Planning Application Reference No.: 3/2022/0465

Address of Development: Chatburn Post Office

I would like to comment on the above planning application which proposes a change of use from the current two bed flat to 3 self contained flats.

proposed north elevation

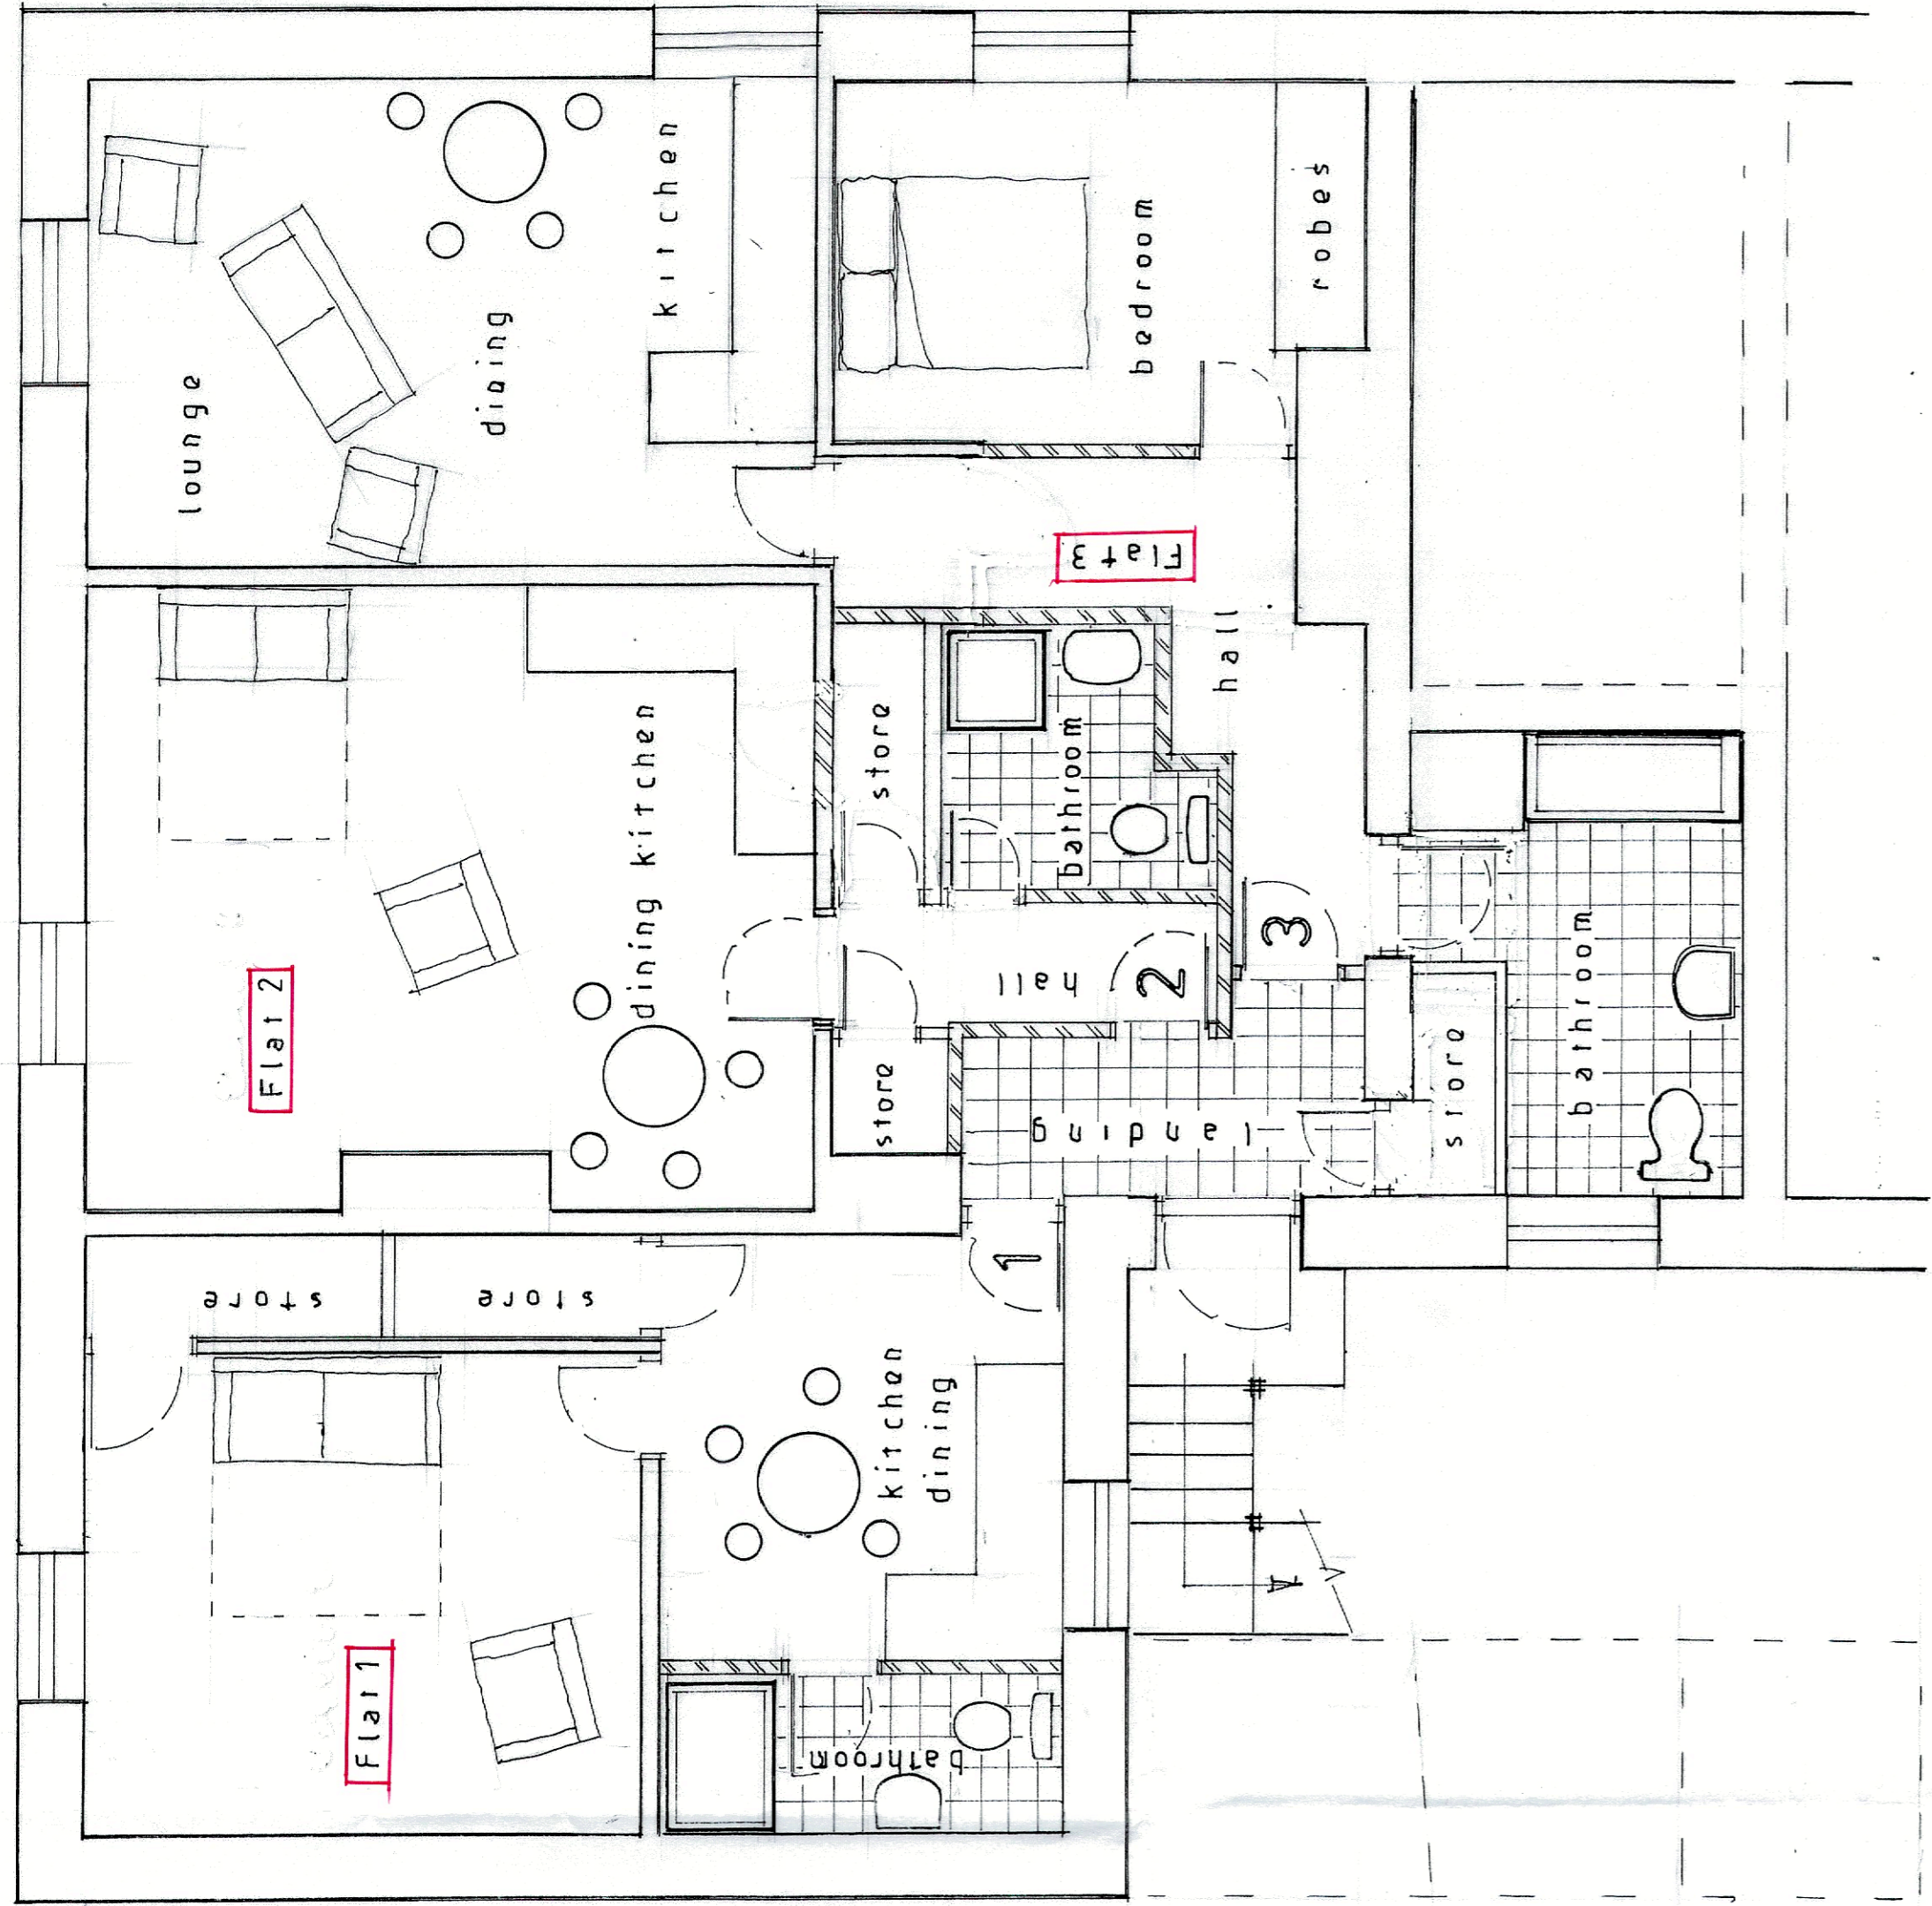
* From the plan - 'Proposed North Elevation' it is difficult to tell if the staircase is on the outside of the building or on the inside.

If the plan is to place it on the outside this would be a total eyesore in what is currently an attractive part of the village (which is a conservation area).

If the stairs were to be inside the passageway then this is yet another obstruction in what is not a large amount of space.
